Application Reference: 2025/0500

Site Address: 14 Hollowdene, Gawber, Barnsley, S75 2NQ

This application seeks full planning permission for the erection of a two-storey rear extension.

Drawing Title **PROPOSED PLANS**

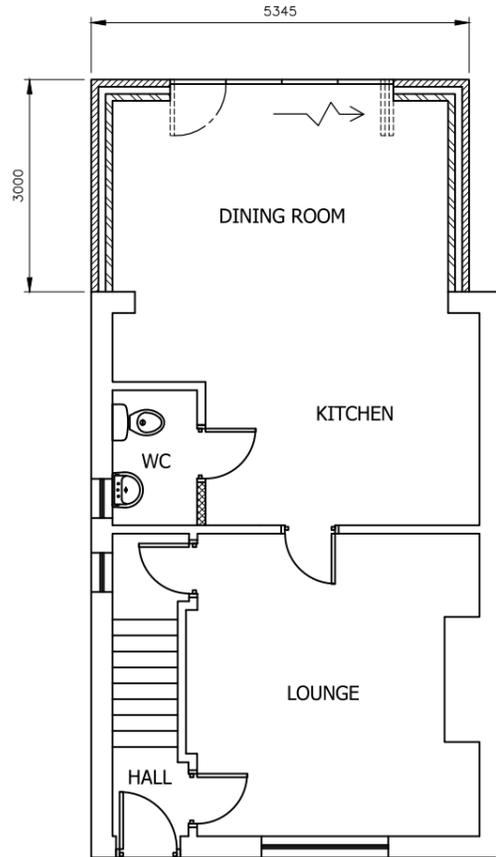
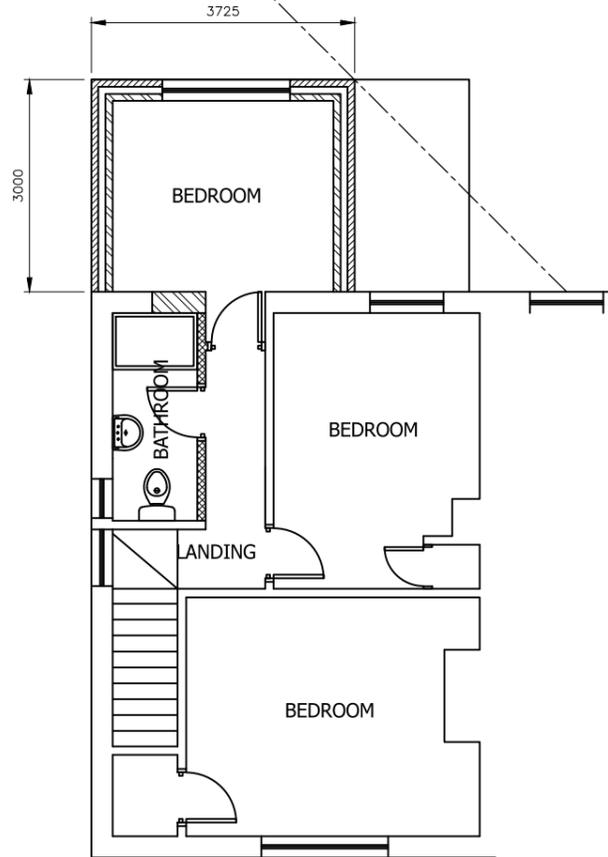
Although proposed as a two-storey extension, the extension is partly single storey. The extension has been designed such that the ground floor element is nearly the full width of the rear wall of the existing house and has a height of 3.6m; and the first floor element is significantly inset from the joint boundary with the adjoining semi such that the two storey element would not break a 45 degree line drawn from the middle of the neighbours closest bedroom window. It has a pitched roof which is set down from the height of the main house roof. The extension does not have any windows proposed in either side elevation, projects 3 metres from the back wall of the existing house and the proposal indicates that the extension would have red brick and grey slate tiles to match those on the existing house.

The SPD recognises that two storey extensions can have a greater impact in terms of overshadowing than single storey extensions; it recommends that two storey rear extensions should not normally abut a party boundary and should be designed with a rear projection of less than 3.5 metres. It also establishes the 45-degree test and it is demonstrated on the submitted first floor plan that the two-storey element does meet the 45-degree test. The extension does not include any new windows in the side walls that could affect the privacy of neighbouring houses. It is concluded that the proposal would not result in any material harm to the amenity of neighbouring properties and is in compliance with Local Plan policy GD1. This carries moderate weight in favour of the application.

Drawing Title **PROPOSED ELEVATIONS**

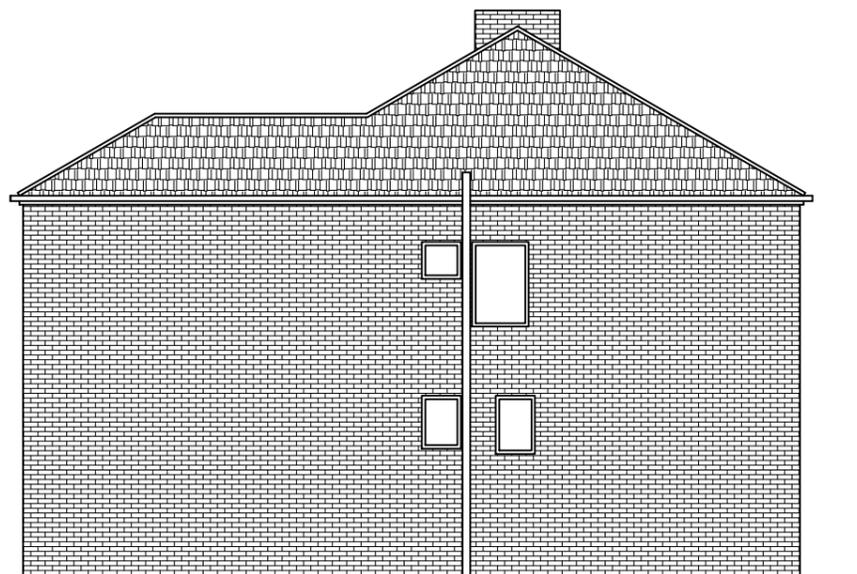
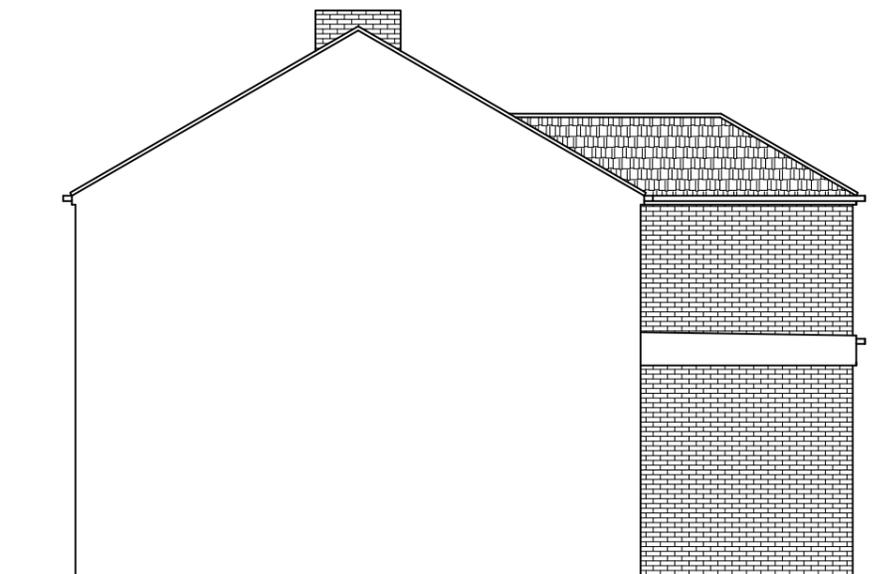
The Supplementary Planning Document for House extensions and other domestic alterations indicates that single storey extensions on semi-detached dwellings should not have an eaves height exceeding 2.5 metres where the extension would project beyond 3 metres. The proposed single storey element, with a flat roof at a height of 3.6 metres, does exceed 2.5 metres, but it projects exactly 3 metres. The semis have significant underbuild to the rear, which means that the impact of the height of the extension is less than might be expected; and the single storey extension, alone, would be permitted development. Thus, there is a clear fallback position that the applicant could employ, and it is concluded that the

impact of the ground floor element alone would not adversely affect the amenity of the adjoining dwelling to an unreasonable degree.
